# ENG-PUDSP21006-R2-GEC.pdf Markup Summary

**Subject:** Stormwater Comment Legend  
**Page Index:** 1  
**Date:** 9/8/2021 3:03:32 PM  
**Author:** EPC Stormwater - Glenn Reese  
**Color:** ■  
**Layer:**  
**Space:**  
**Page Label:** 1

OUTLET STRUCTURE DETAIL - PLAN VIEW  
NO SCALE

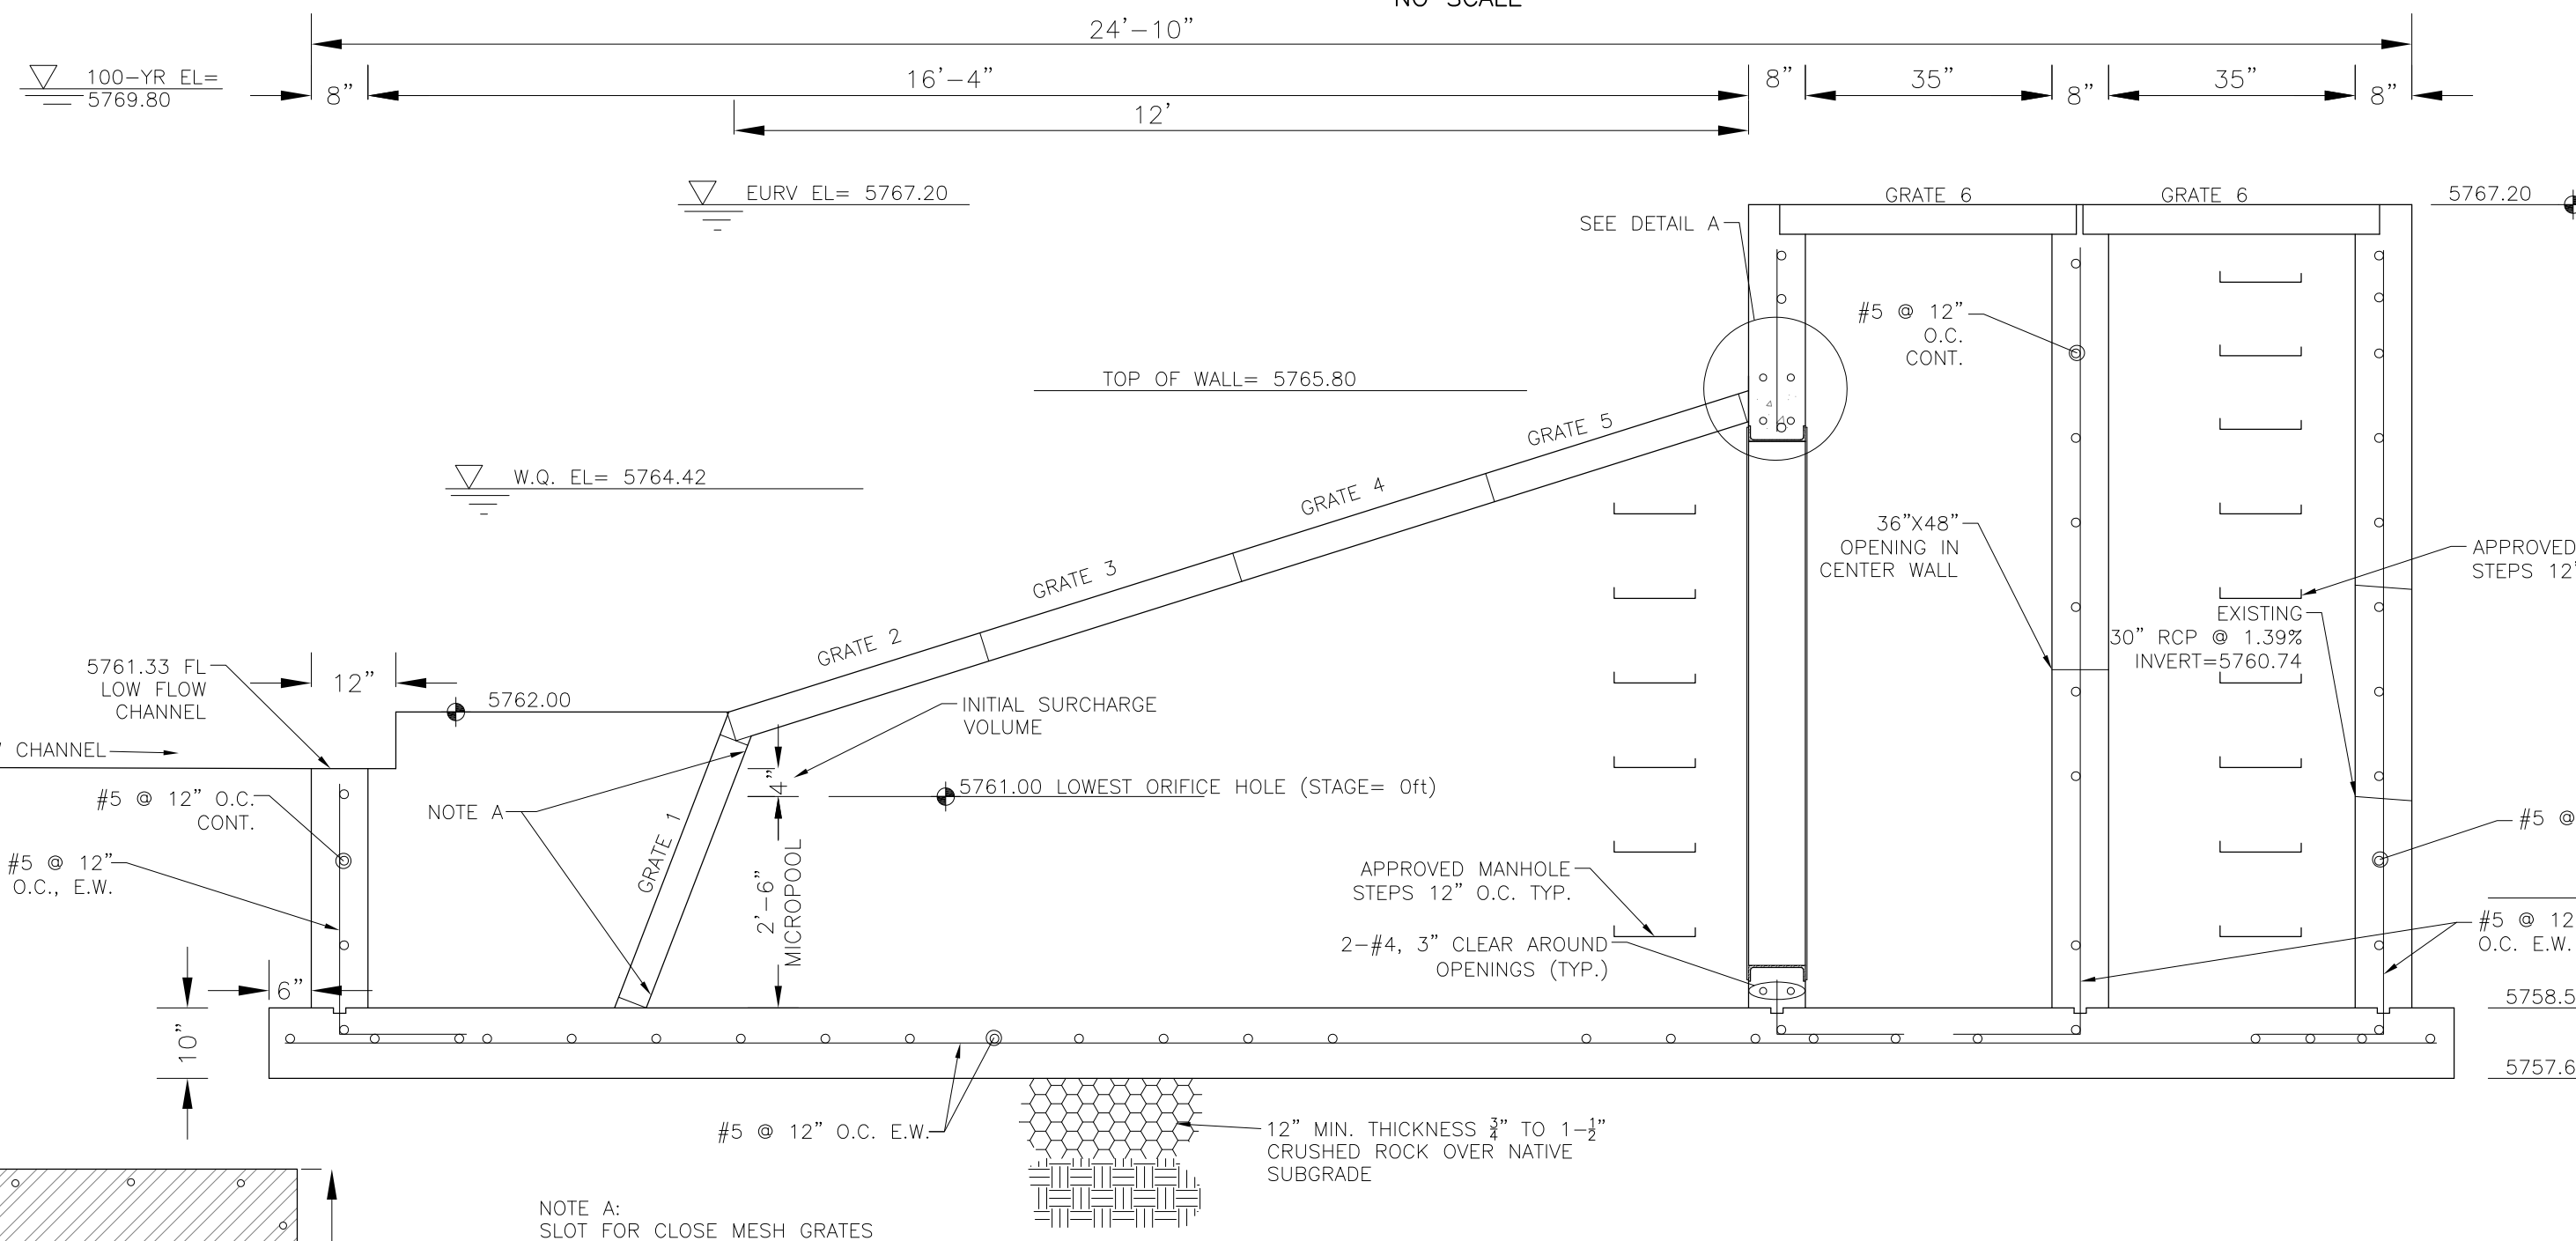
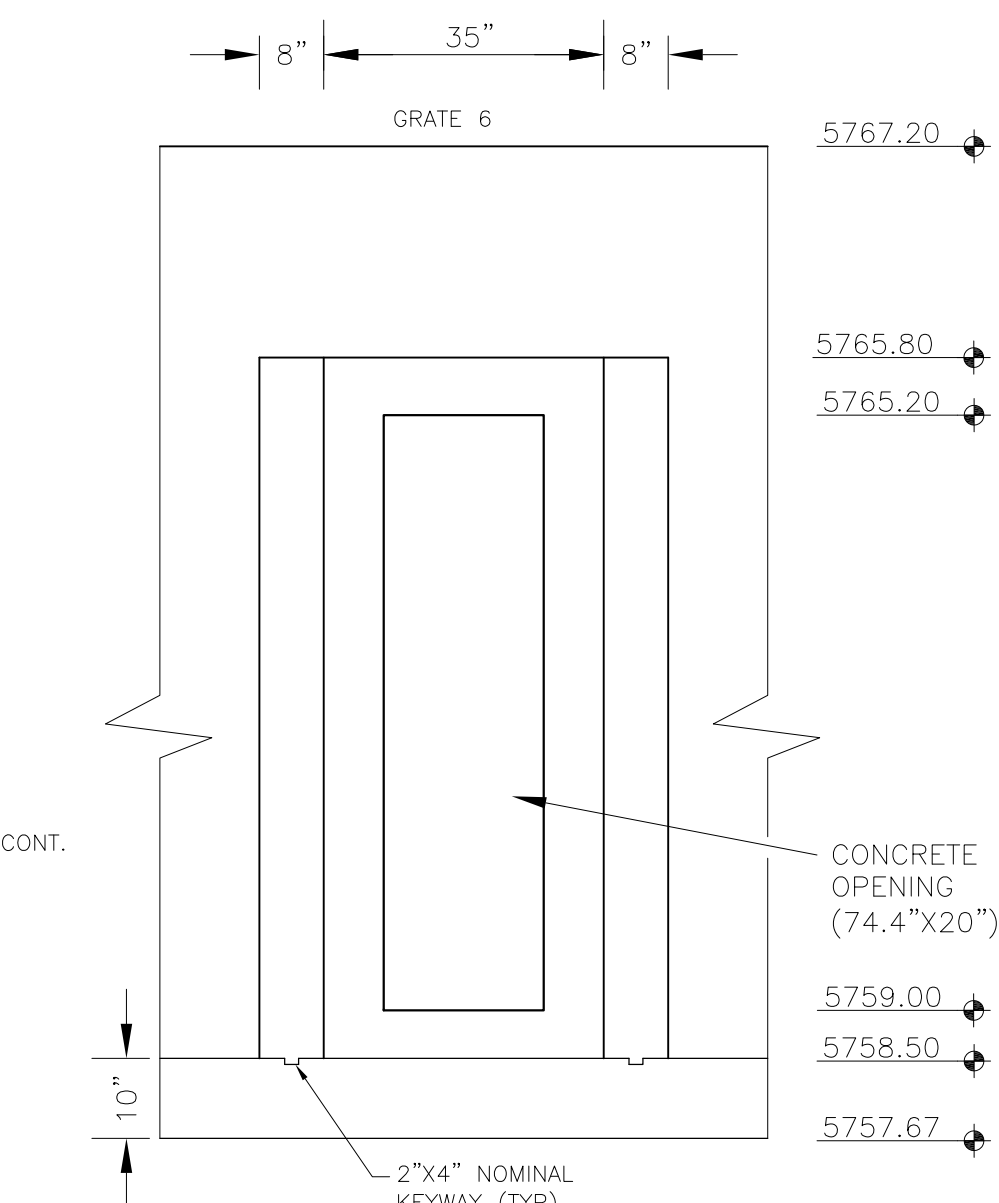
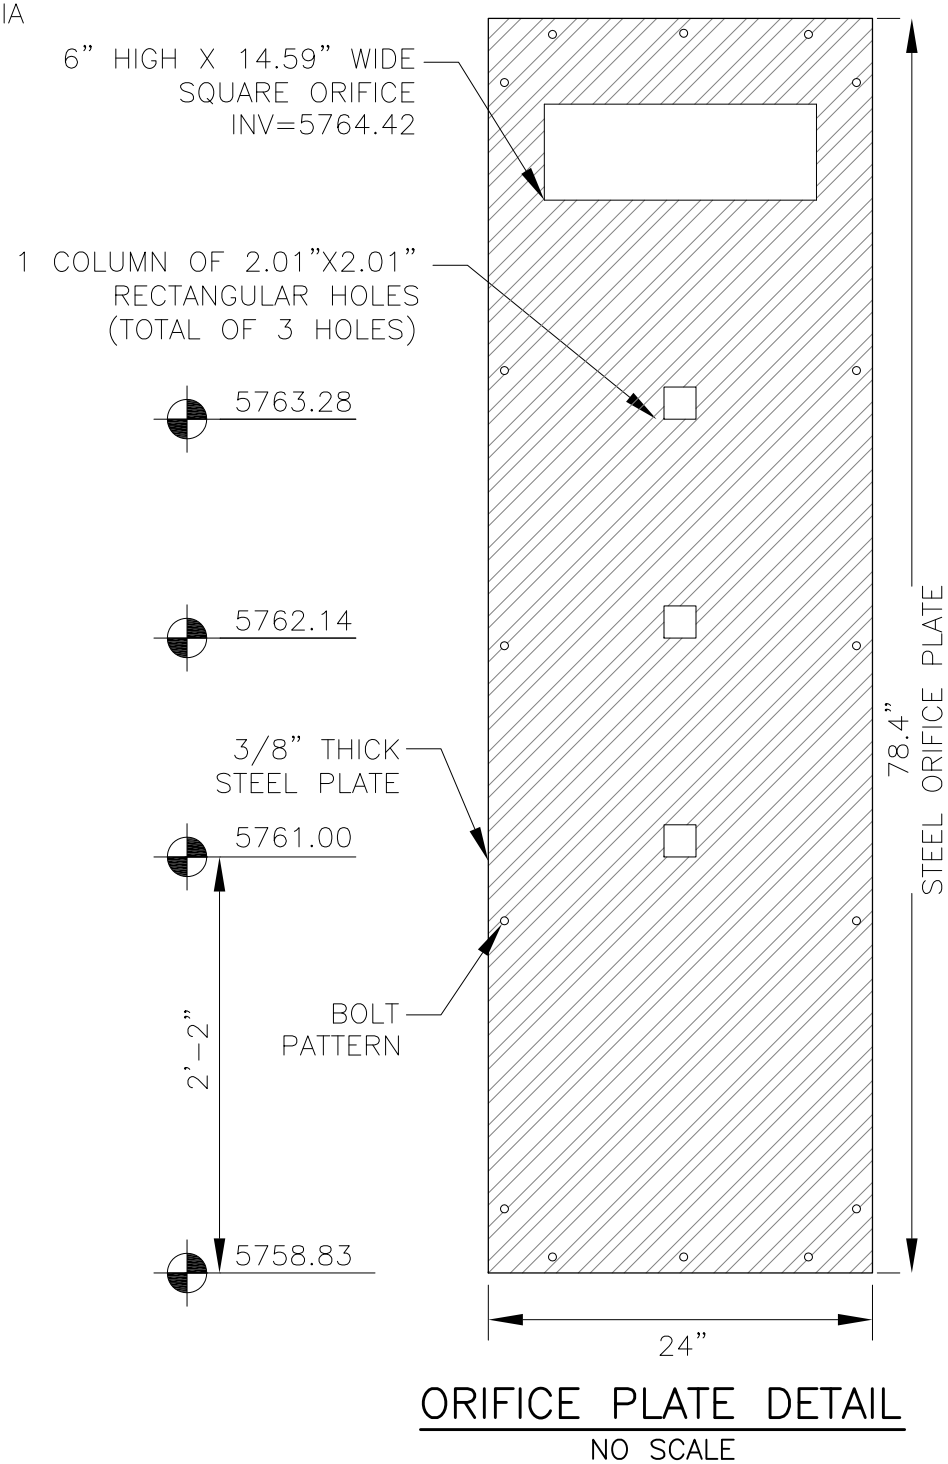
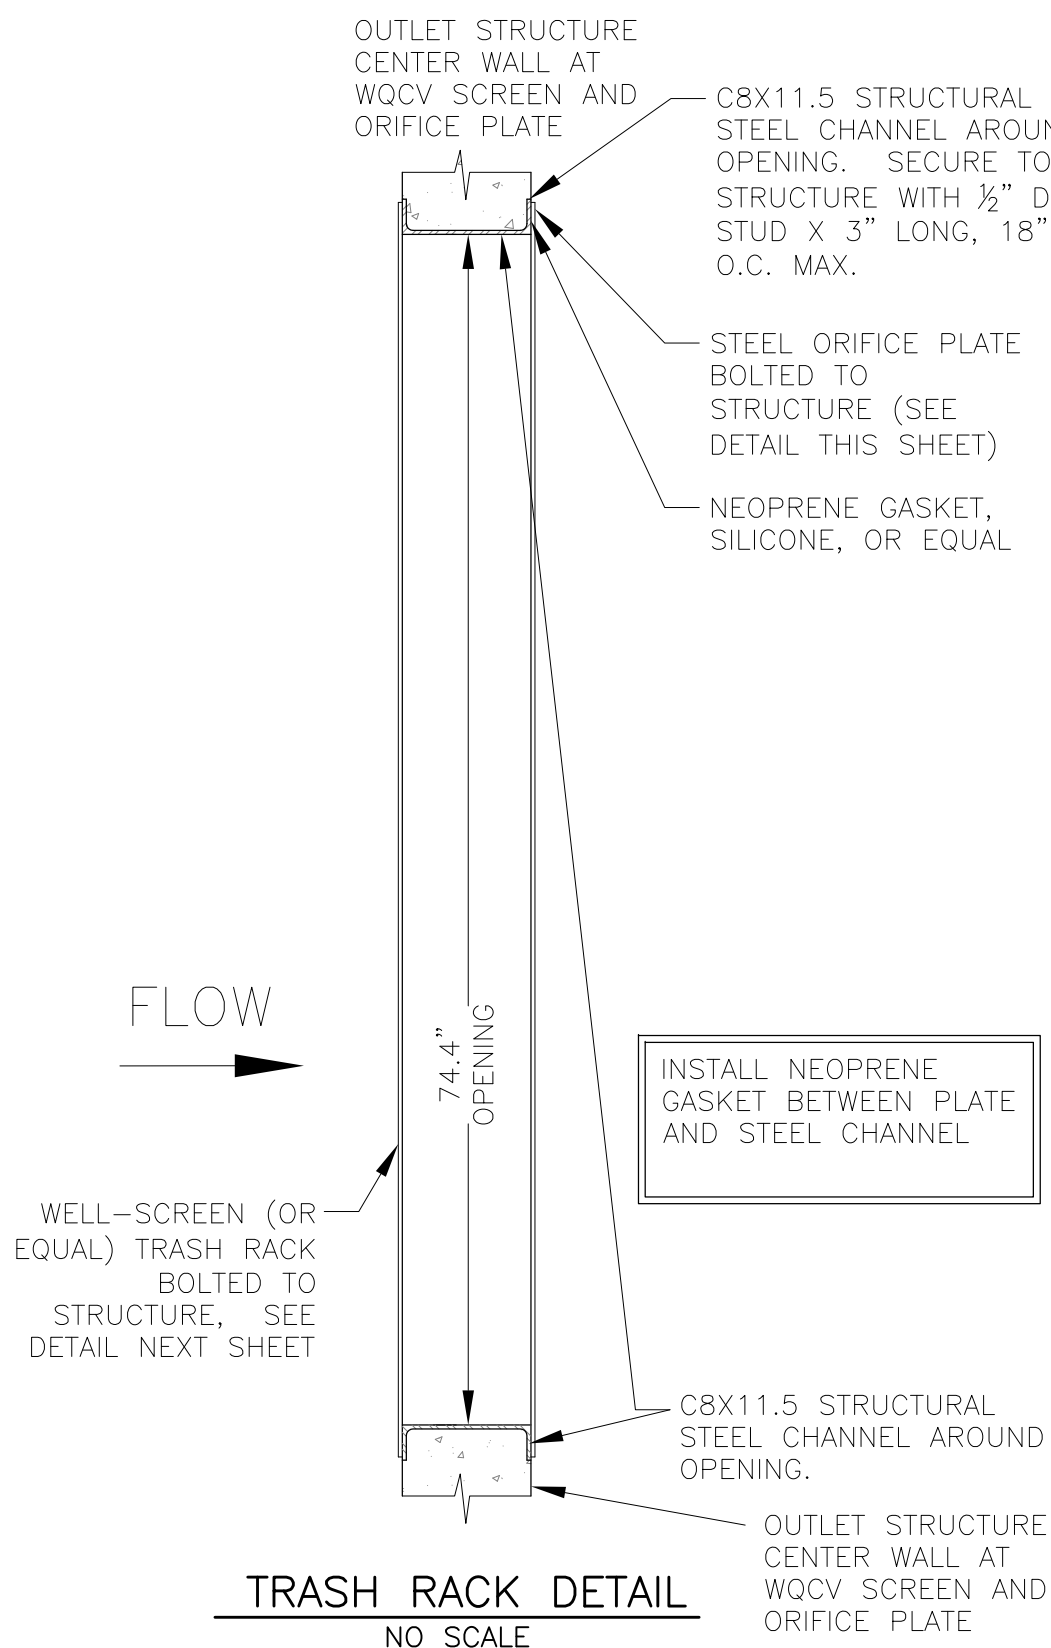
Provide detailed plan and section view of outlet structure too, per calcs shown on pg 193 of PDR.

Per MHFD Detail T-5:  
- pond bottom should have a minimum slope of 3%.  
- trickle channel should have a slope between 0.4% - 1%
